Modify existing site development plan to allow white faces on its wall signs (the site development plan currently requires green faces)

Meeting/Hearing Date:	Fee Total:
Staff Signature:	Date:
	Project # PR-2020-003539

Re: Minor Amendment to Site Development Plan Approved Prior to the Effective Date of the IDO
Starbucks Coffee, 1450 Montano Road NE, GP-2019-44591

INTERNALLY LIT
INDIVIDUAL CHANNEL
LETTERS (GREEN) WHITE
& 'DRIVE-THRU' OVAL
48 SQ. FT. MAX.

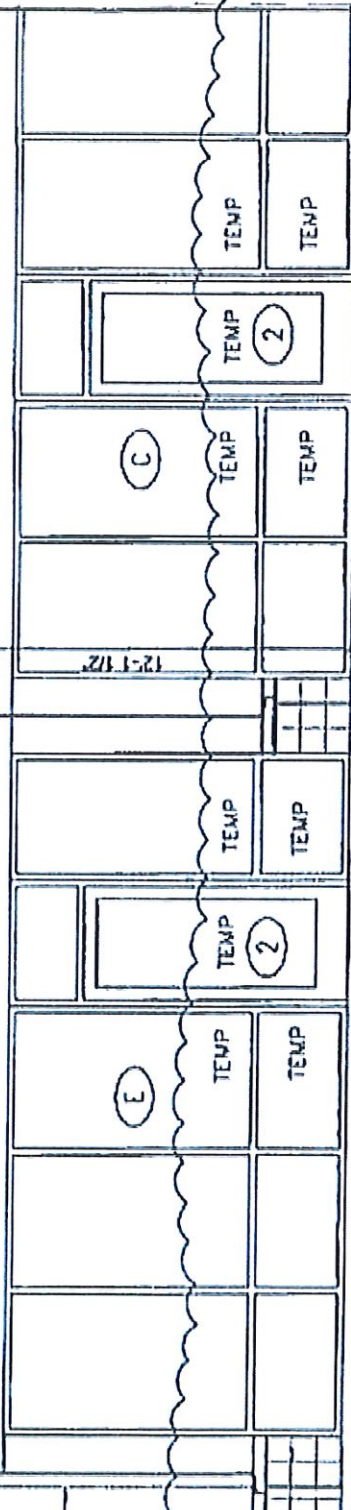
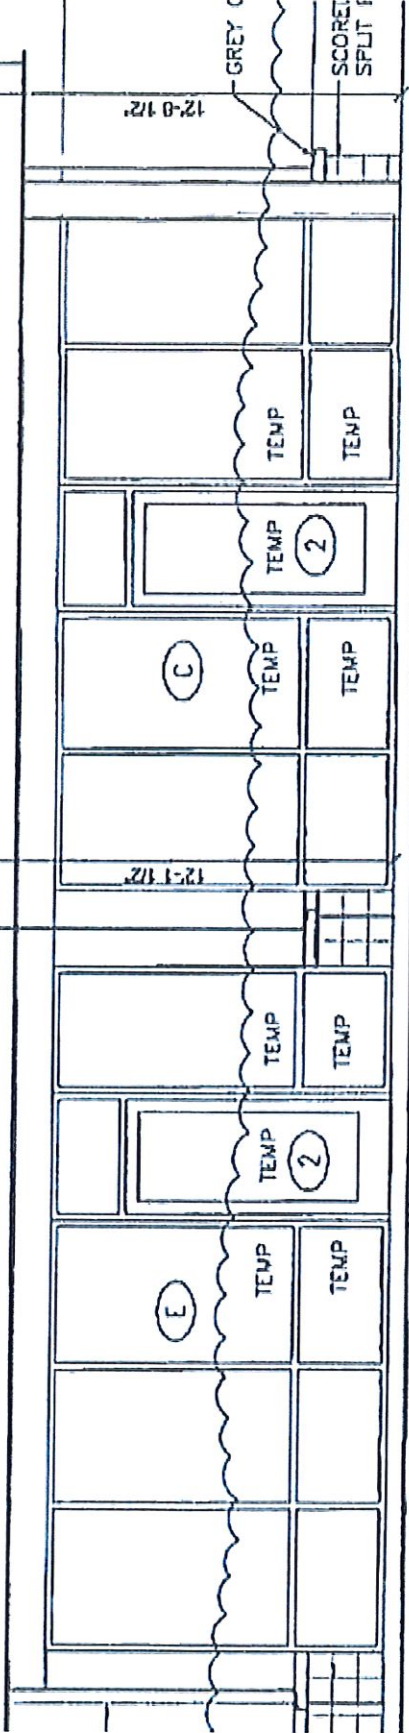
YESCO, LLC, for Starbucks Coffee, respectfully requests that the site development plan be modified to reflect that the pan channel letters may have white faces at its 1450 Montano Road location. This request has been approved by the land owner Chenga Realty Group, LLC through their representative Richard T. Murphy per the provided land owner approval letter. Please consider approval of this Minor Amendment to Site Development Plan as submitted.

B INTERNALLY ILLUMINATED 18" TALL PAN CHANNEL LETTERS
 SCALE: 1/2" = 1'-0" Permitting: 22.17 SF

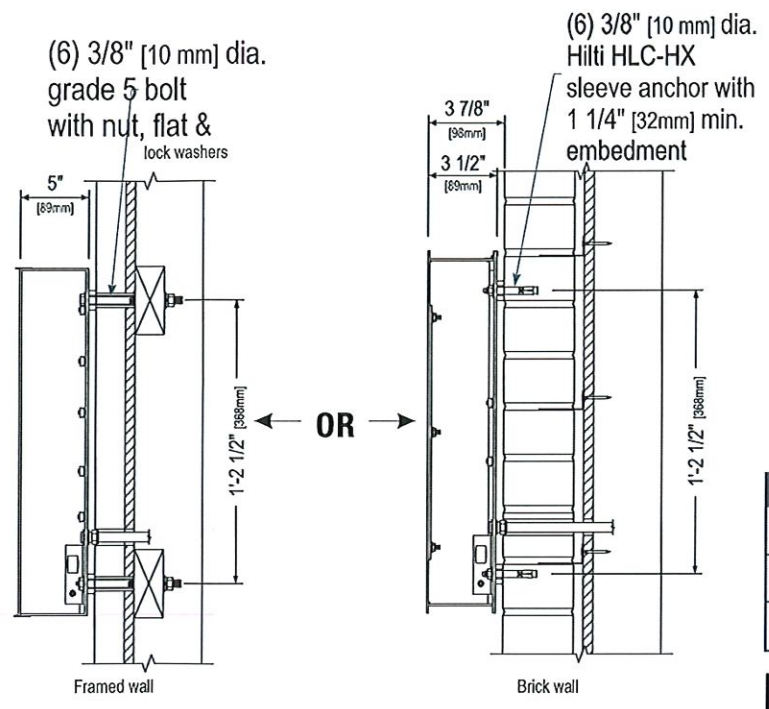
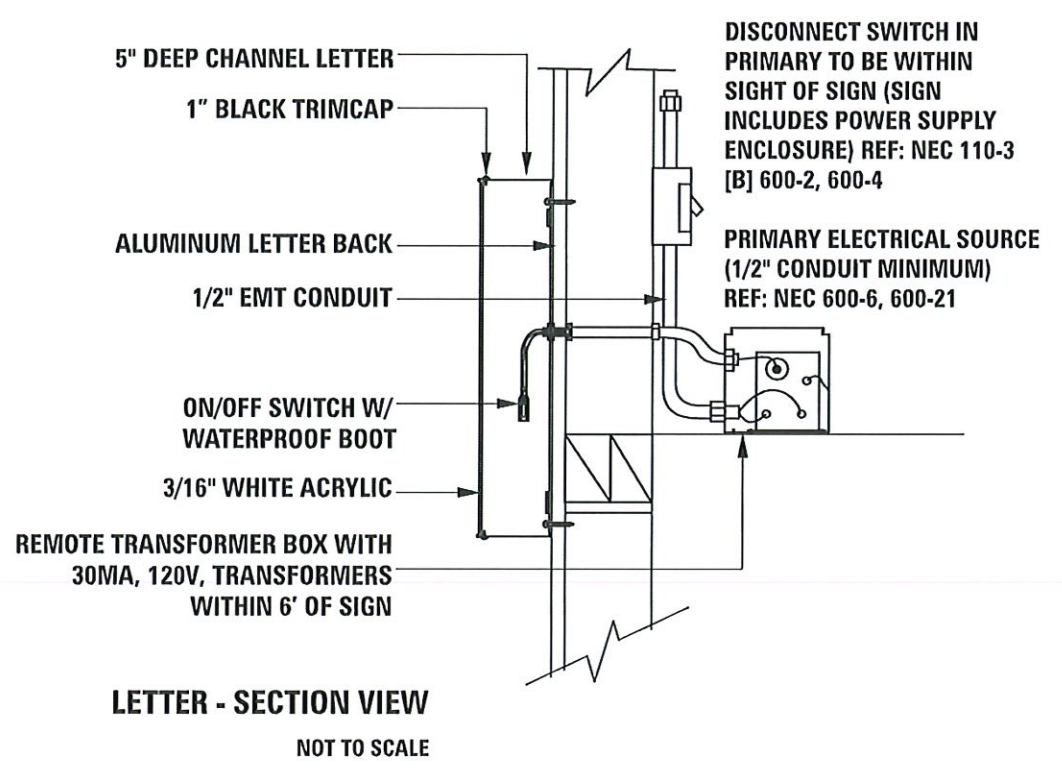
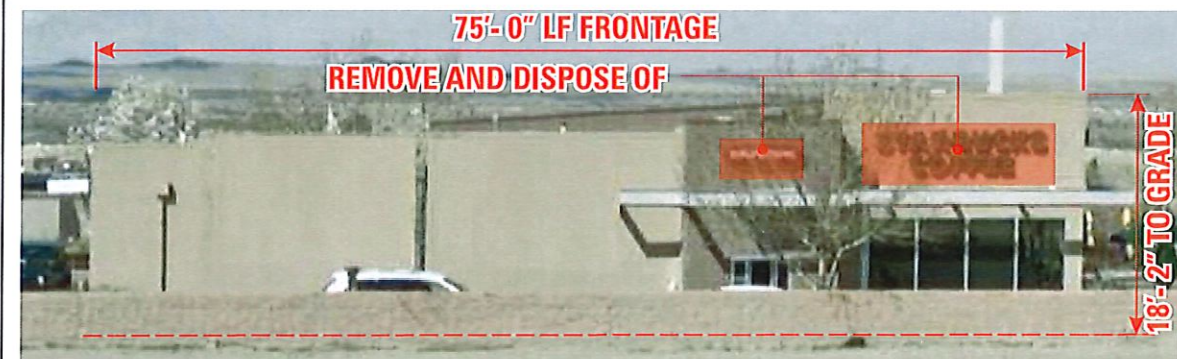
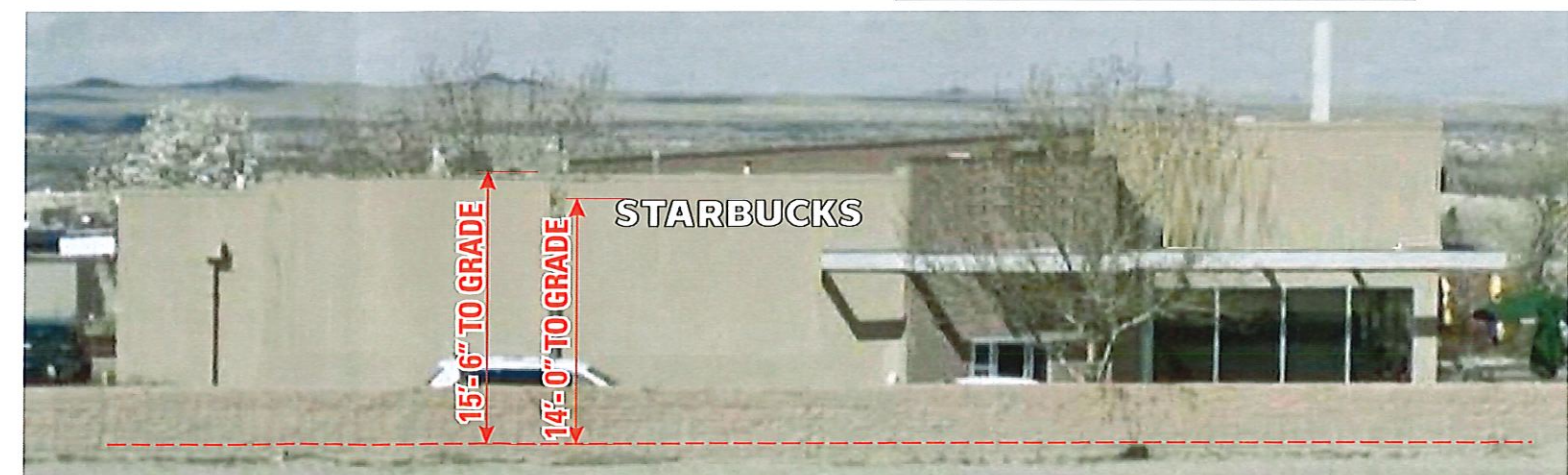
Starbucks Coffee is in a process of refurbishing and rebranding many of their stores throughout the country, a process which includes the location at 1450 Montano Road, NE, Albuquerque, NM 87107. As part of this rebranding effort, Starbucks is eliminating green faces on their "Starbucks" channel letters. In the process of filing for appropriate permits for modification to signage at this location, it became apparent that a site development plan existed for this location which specified that the pan channel letter faces must be green. This site development plan predates the effective date of the new IDO.
